## Office of Environment & Heritage

Your reference : 06\_0074 Mod 3  
Our reference : DOC12/35635  
Contact : Allison Treweek (02) 6229 7082

### **RE- MODIFICATION TO PEPPERTREE QUARRY PROJECT (O06\_0074 MOD 3) EXHIBITION OF ENVIRONMENTAL ASSESSMENT**

Figure 6: Heritage Management Area and Proposed Offset Area

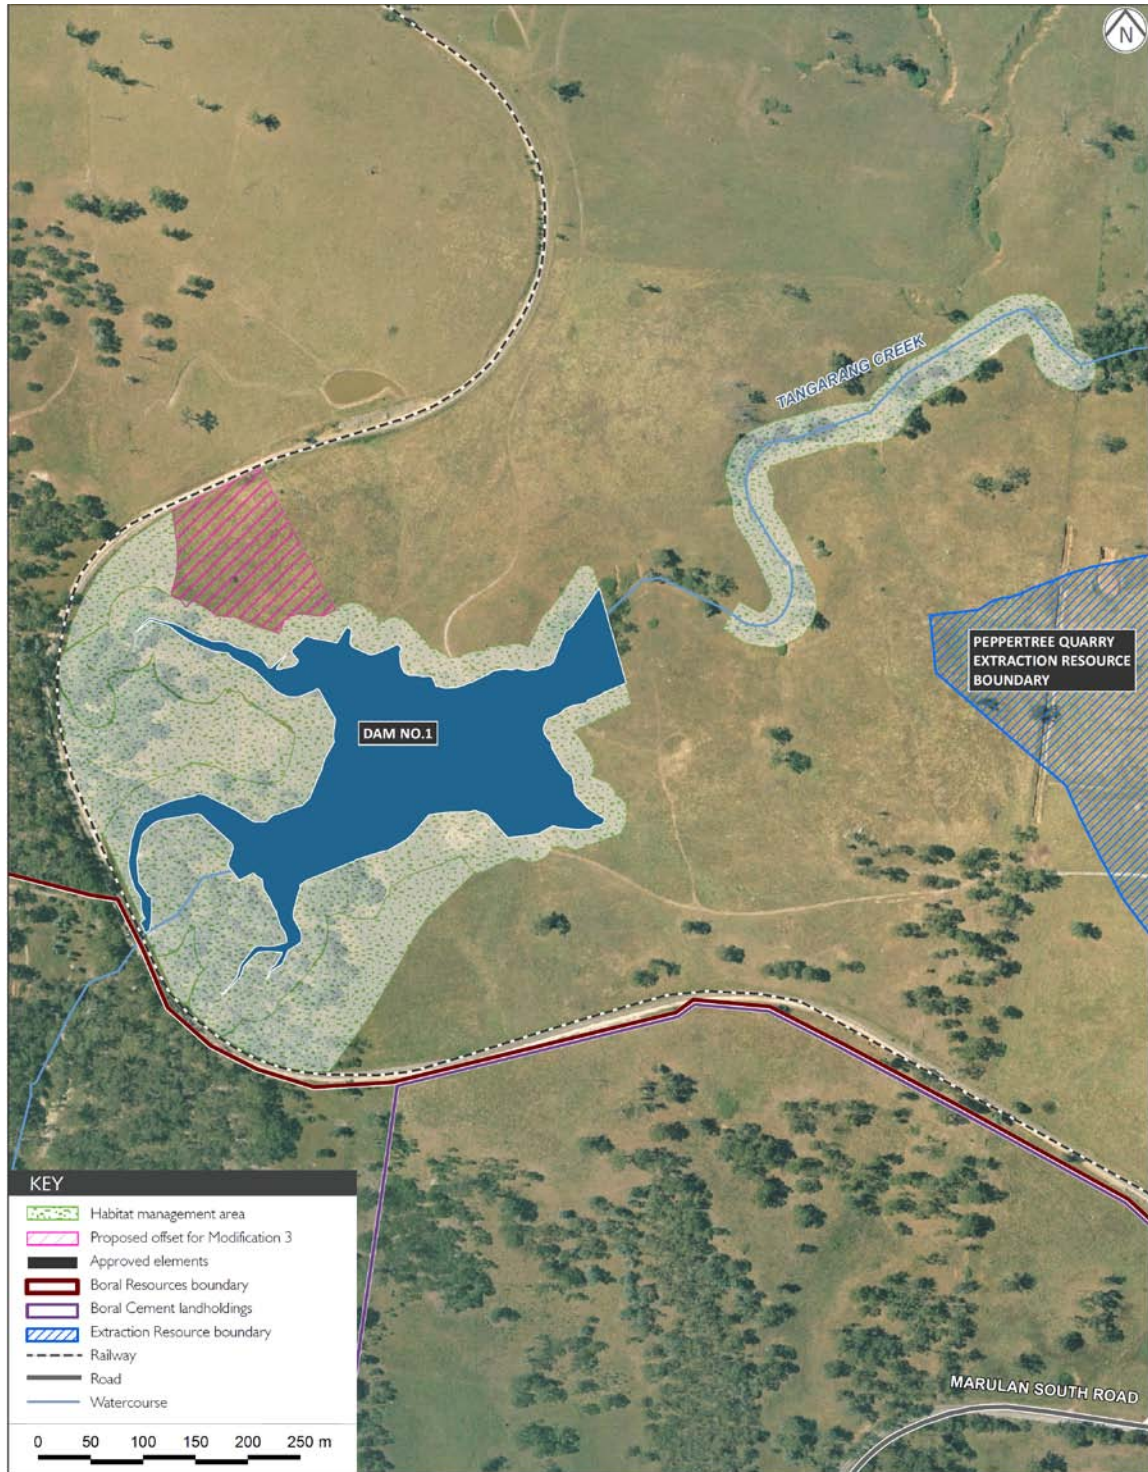
OEH note the area where the HV power line route will impact is surrounded by intact Box gum woodland. The proponent could consider investigating the protection or enhanced management of this area as an offset for this development. Such enhanced management should be above and beyond what is required by legislation such as the Noxious Weeds Act.

Figure 2.1

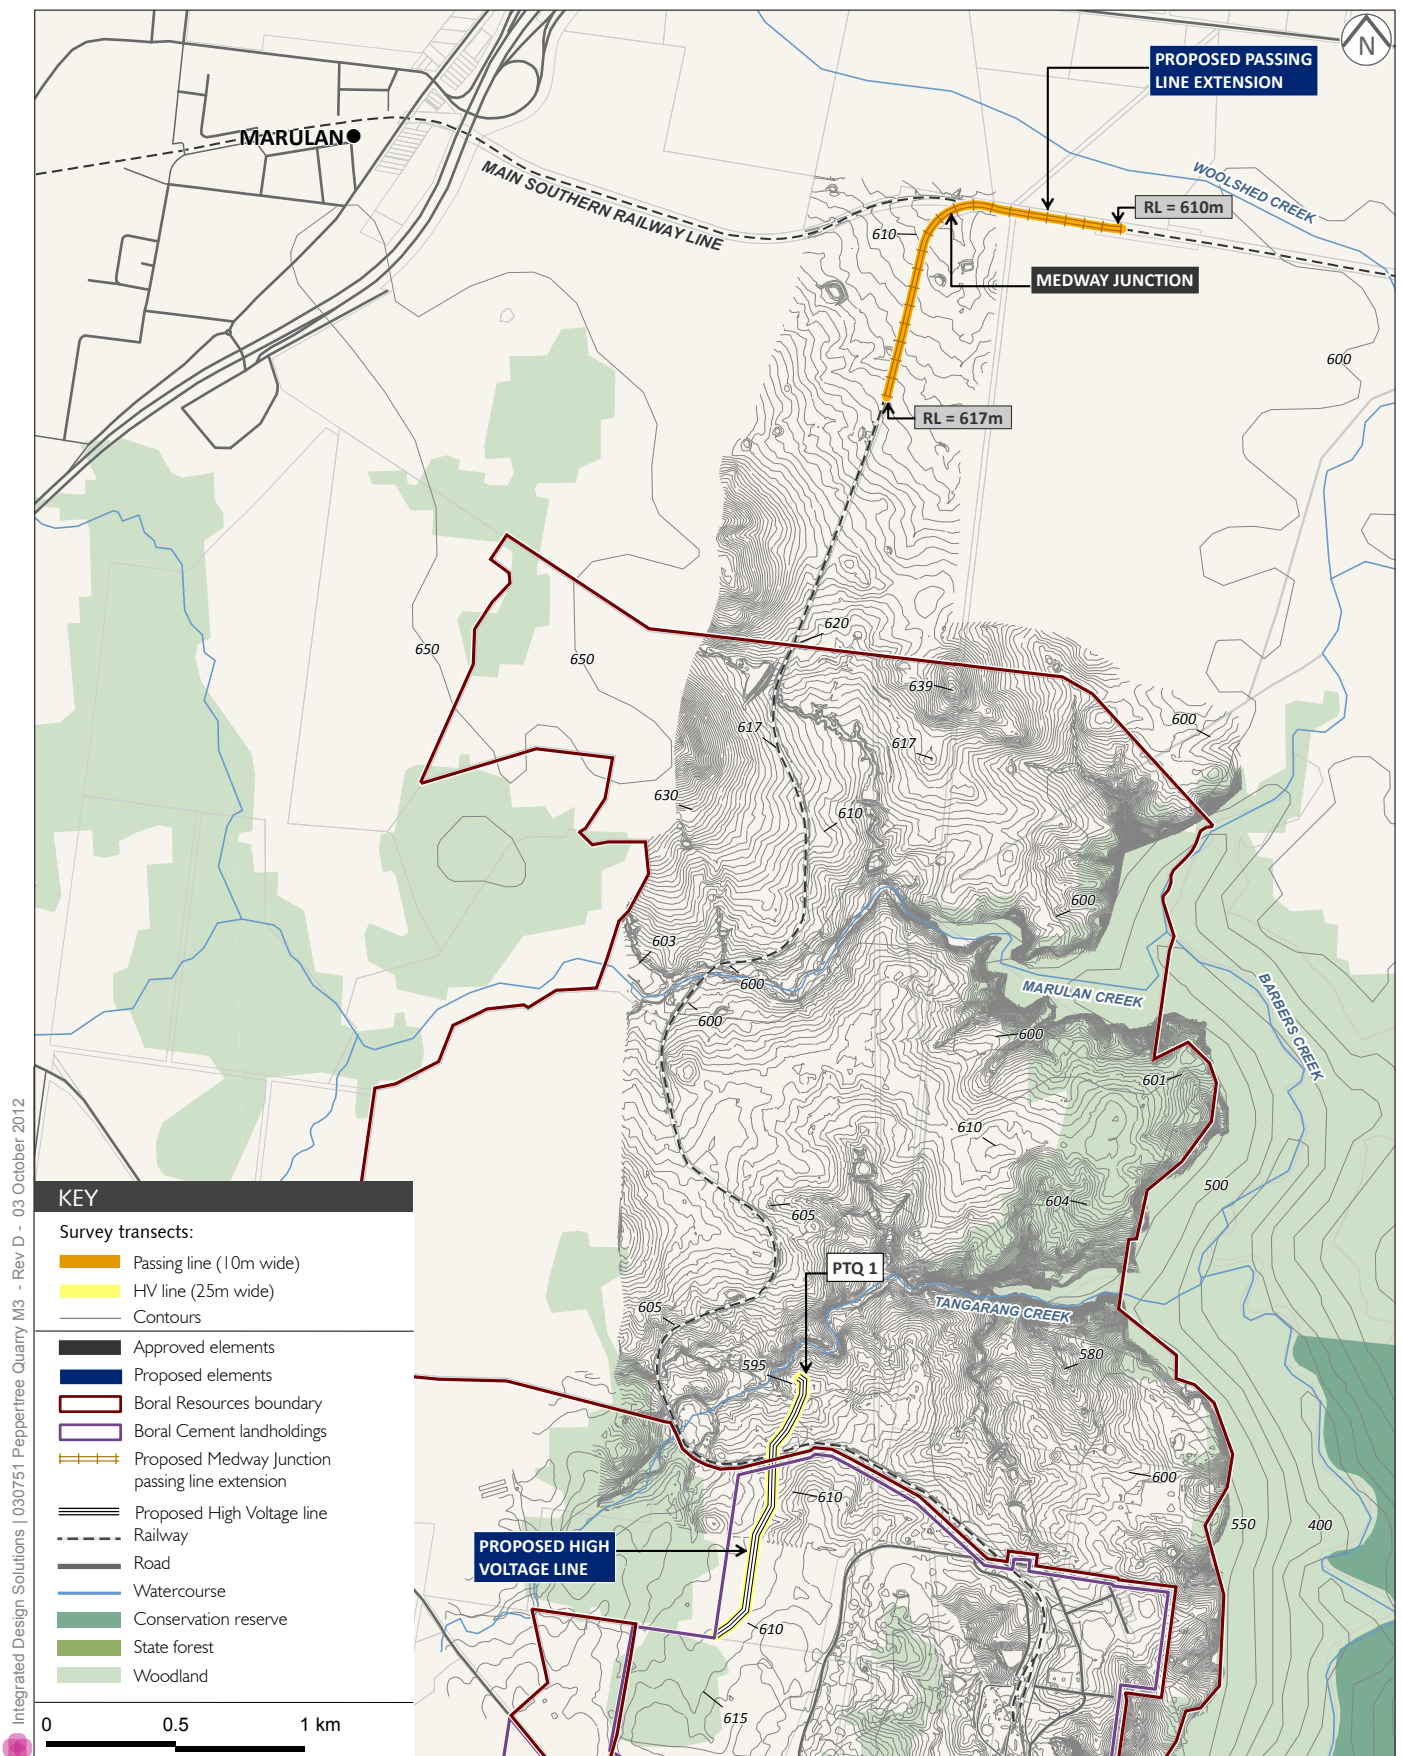
Section 4 – Documentation of the survey strategy and survey units does not meet the requirements stipulated in the 2005 guidelines. For example, the report contains no map that shows the boundaries of the survey units and the route(s) of the survey transects within each unit. There is also no information on survey transect widths. This information is required to calculate effective survey coverage and is a requirement listed in the 2005 guidelines.

Section 4.2 – Survey units must be based on recognised landscape and/or landform units. The units described here do not meet the criteria discussed in the 2005 guidelines.

Figure 2.2

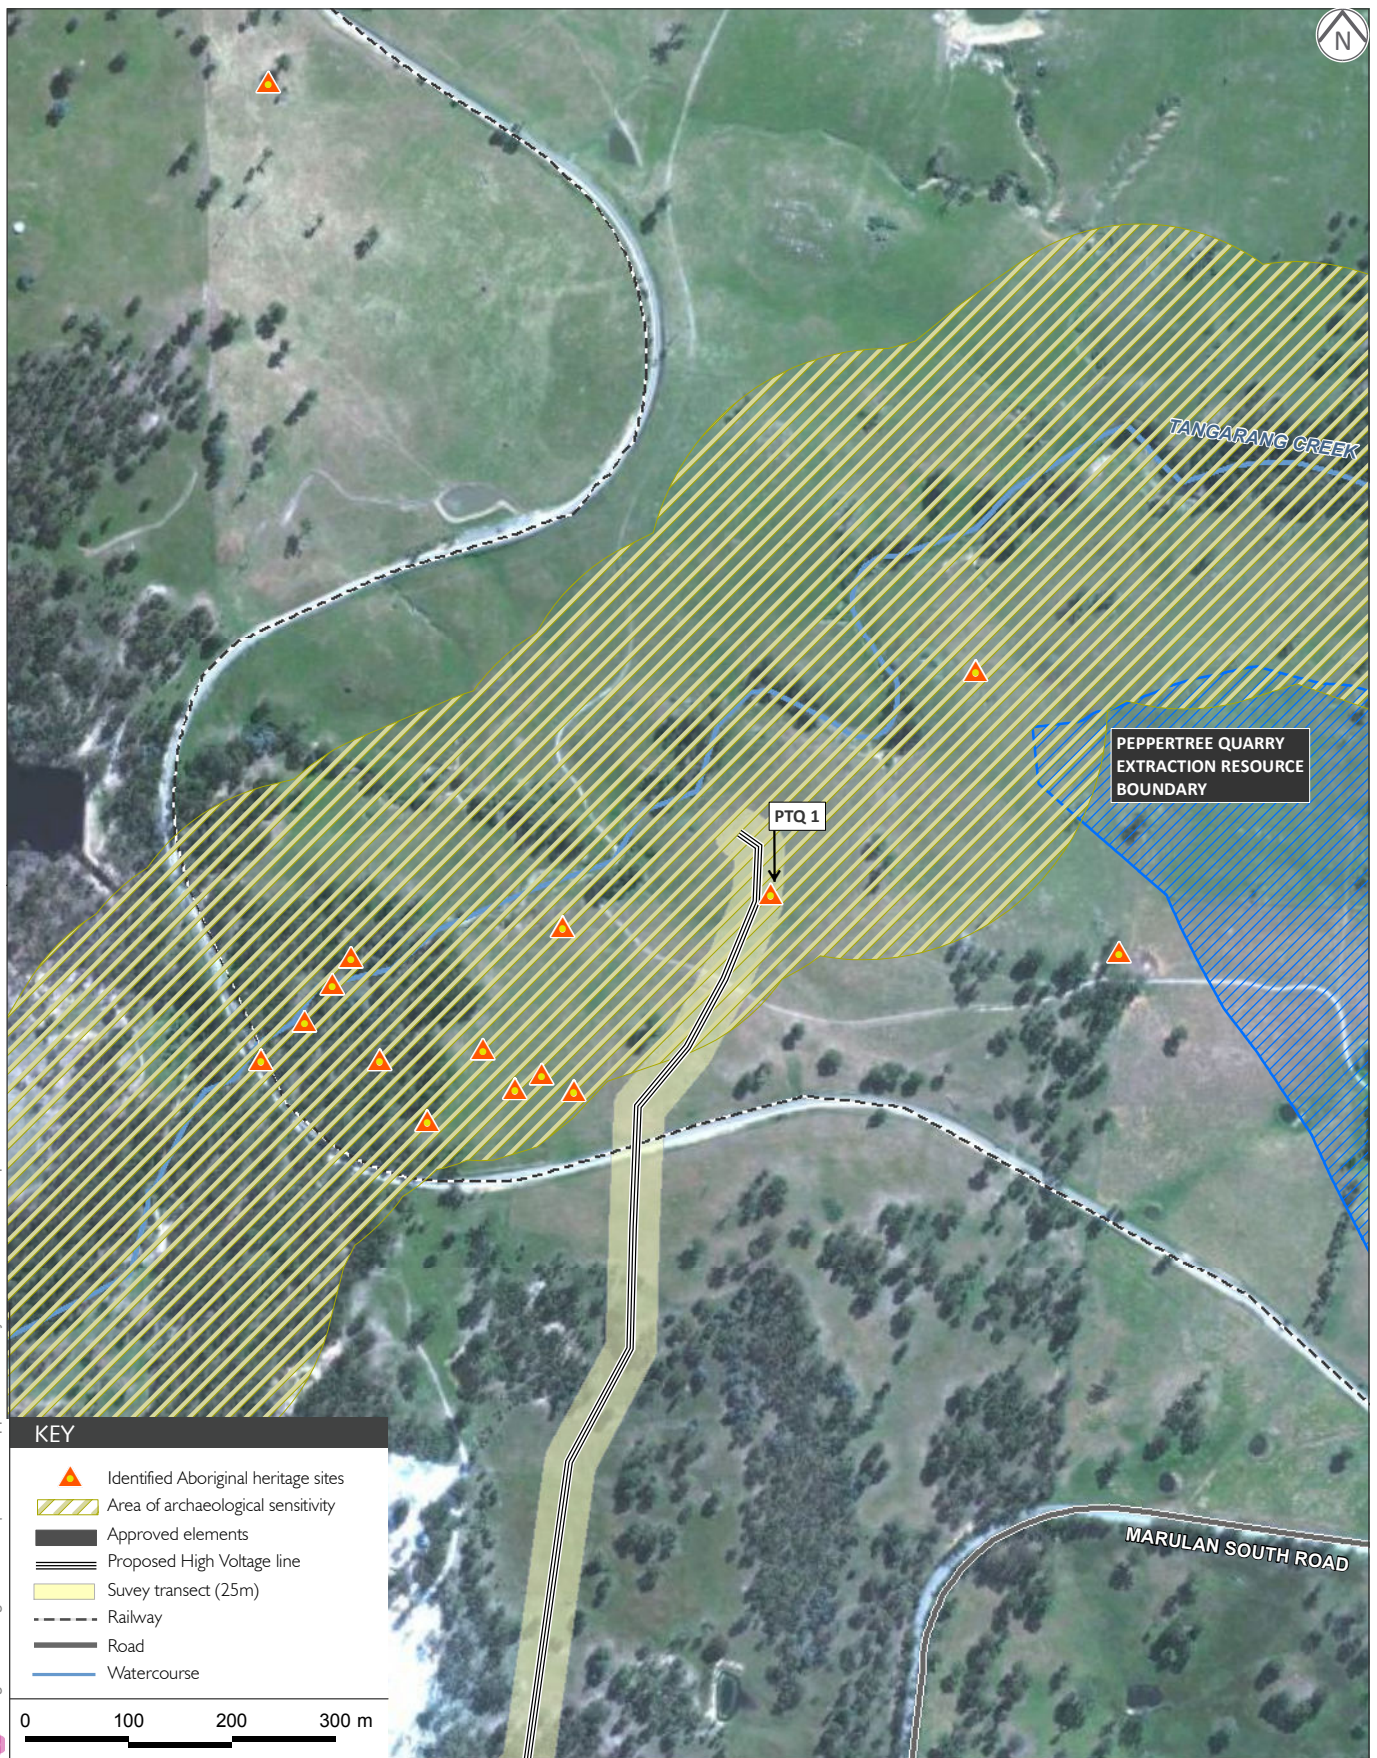
Section 4.3 – Site PTQ2 has not been listed on AHIMS and no site card appears to have been submitted. Section 89A of the NPW Act 1974, as amended and Section 102 of the NPW Regulation 2009 are not overridden by Part 3A of the EP&A Act and it is an offence to not provide a site record card to OEH within a reasonable time of discovery of the site. A completed site card should be forwarded to OEH Queanbeyan as soon as possible.
